May 11, 2021

Re: Car Wash
7201 Wyoming Blvd NE 87109
30-Day Temporary Certificate of Occupancy
Transportation Development Final Inspection
Engineer's/Architect's Stamp dated 6-25-19 (D19D005)
Certification dated 5-5-21

SITE PLAN

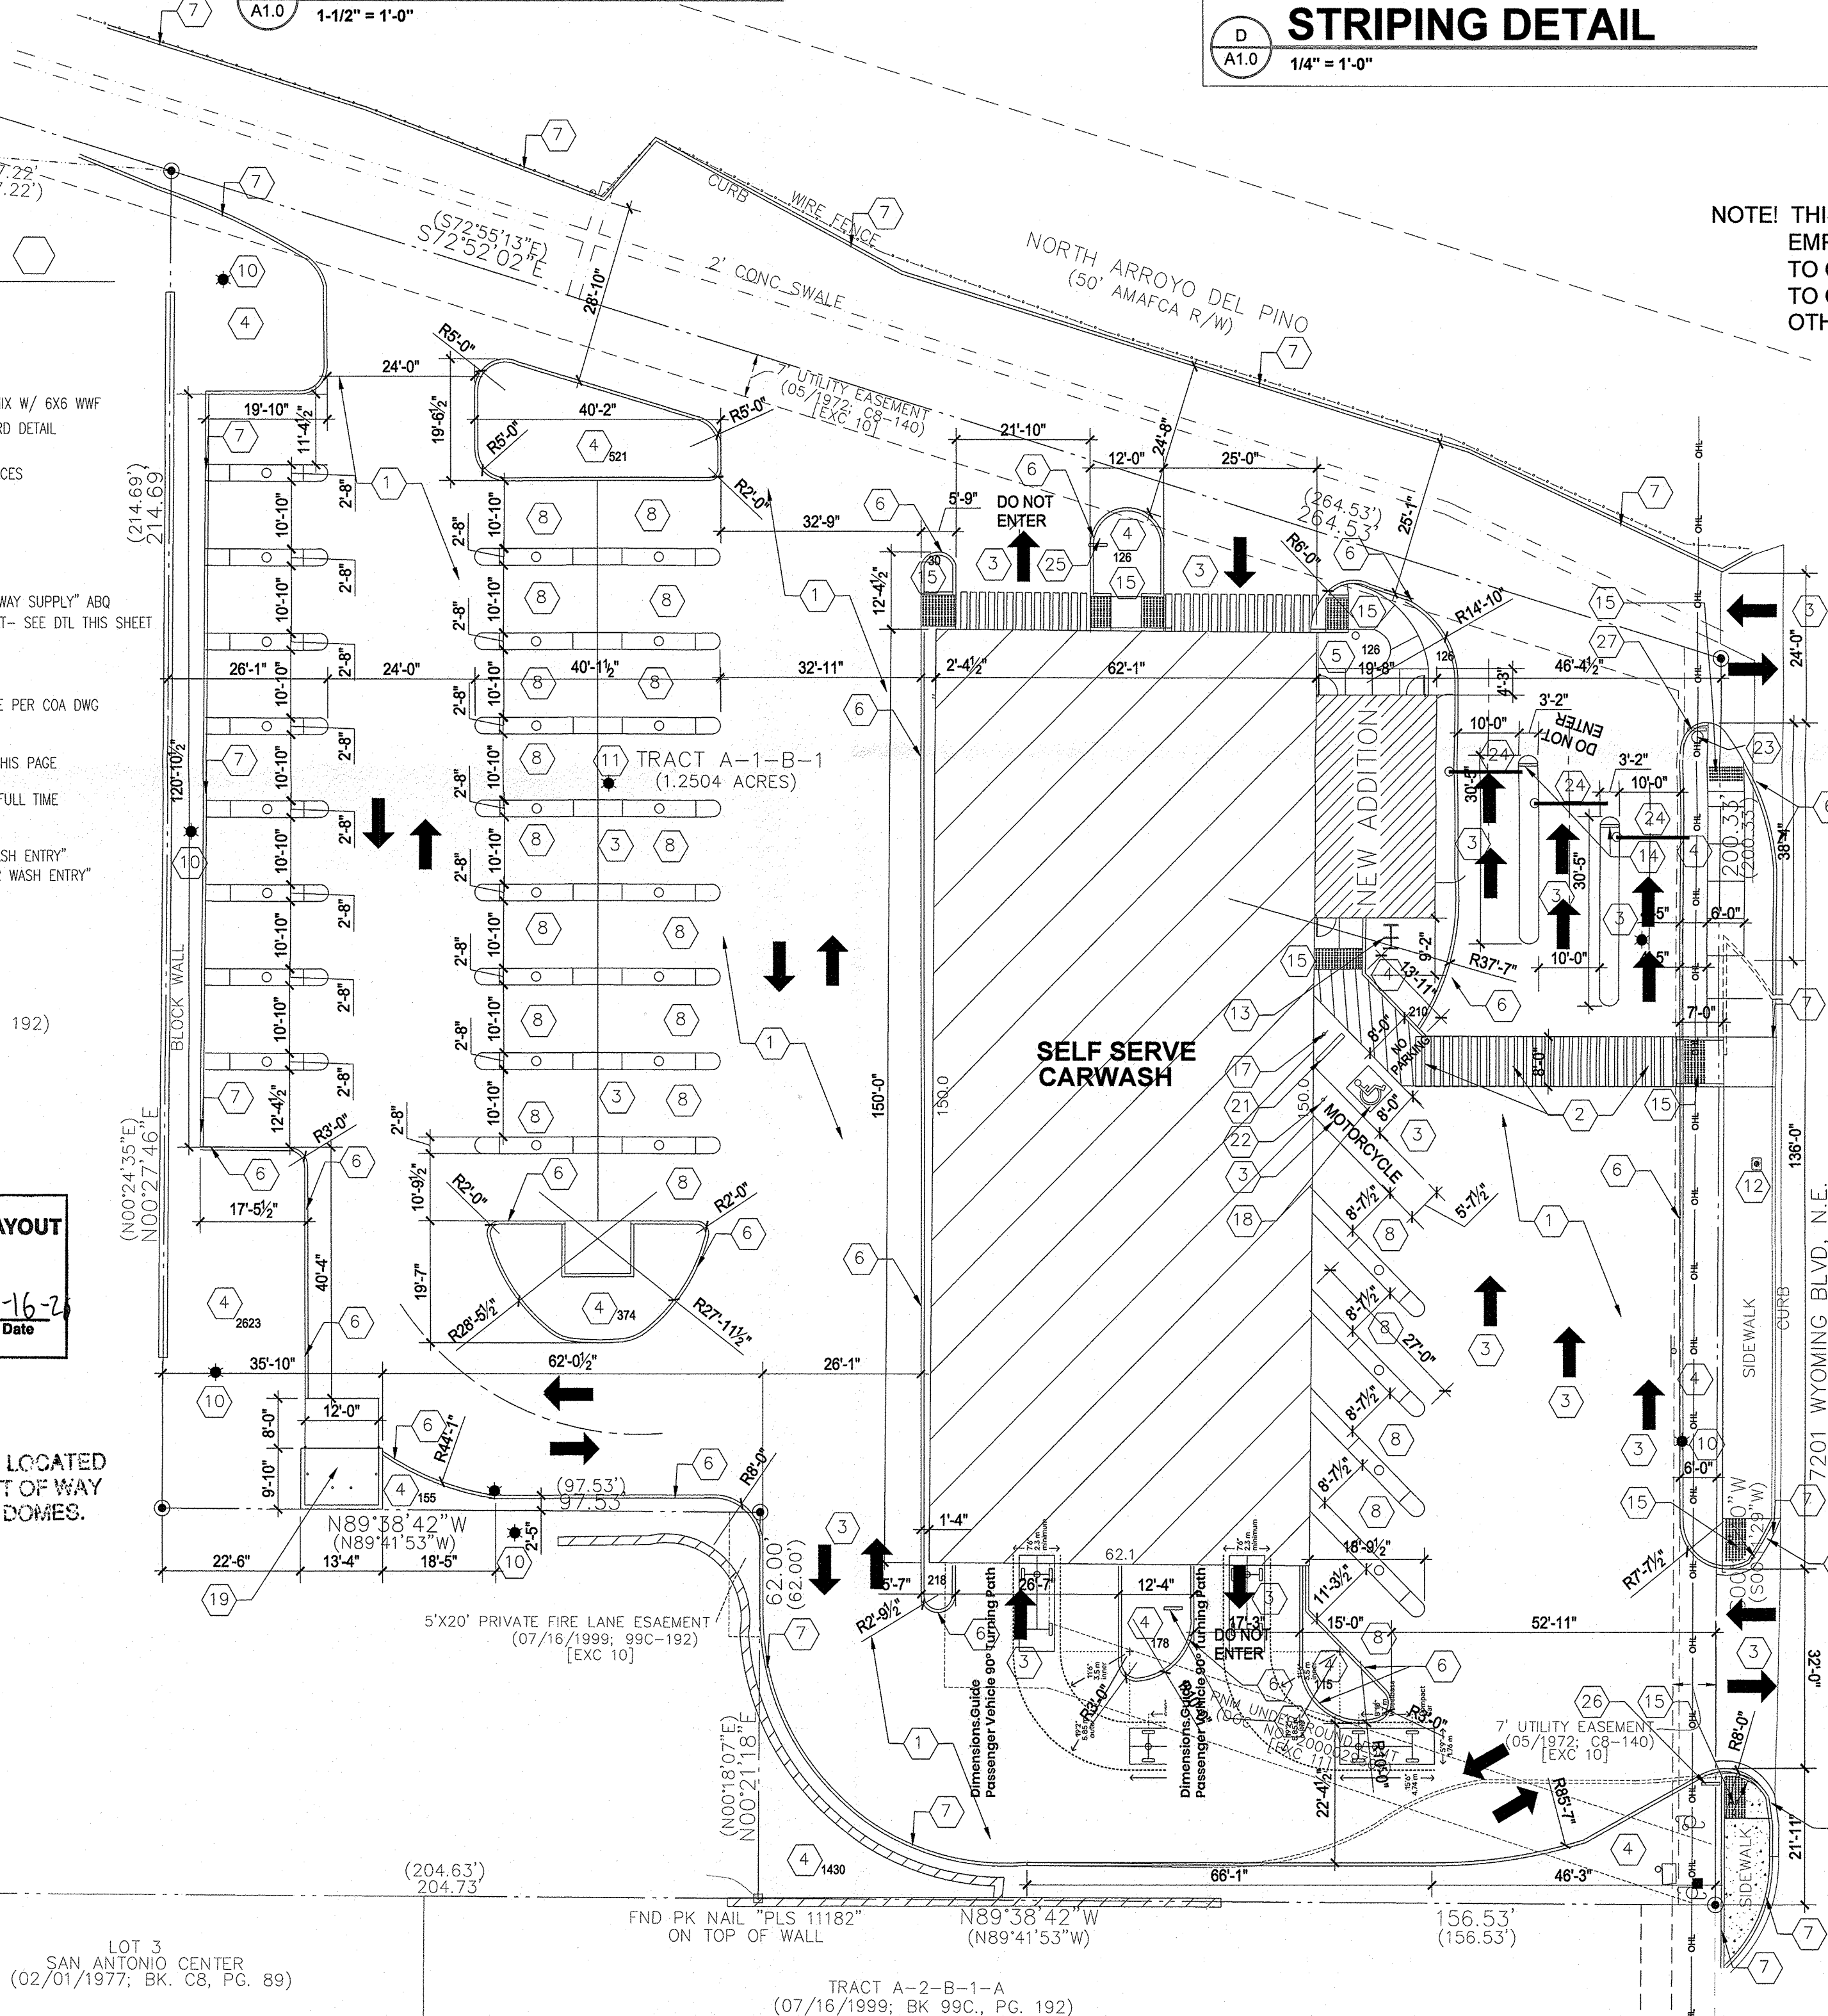
- All site signage shown on plan needs to be in place (handicapped parking, motorcycle, on-way, way-finding, etc.)
- "Do Not Enter" markings are missing in back of the building for the one-way aisles.
- Clear the site of debris around the drive-up area.
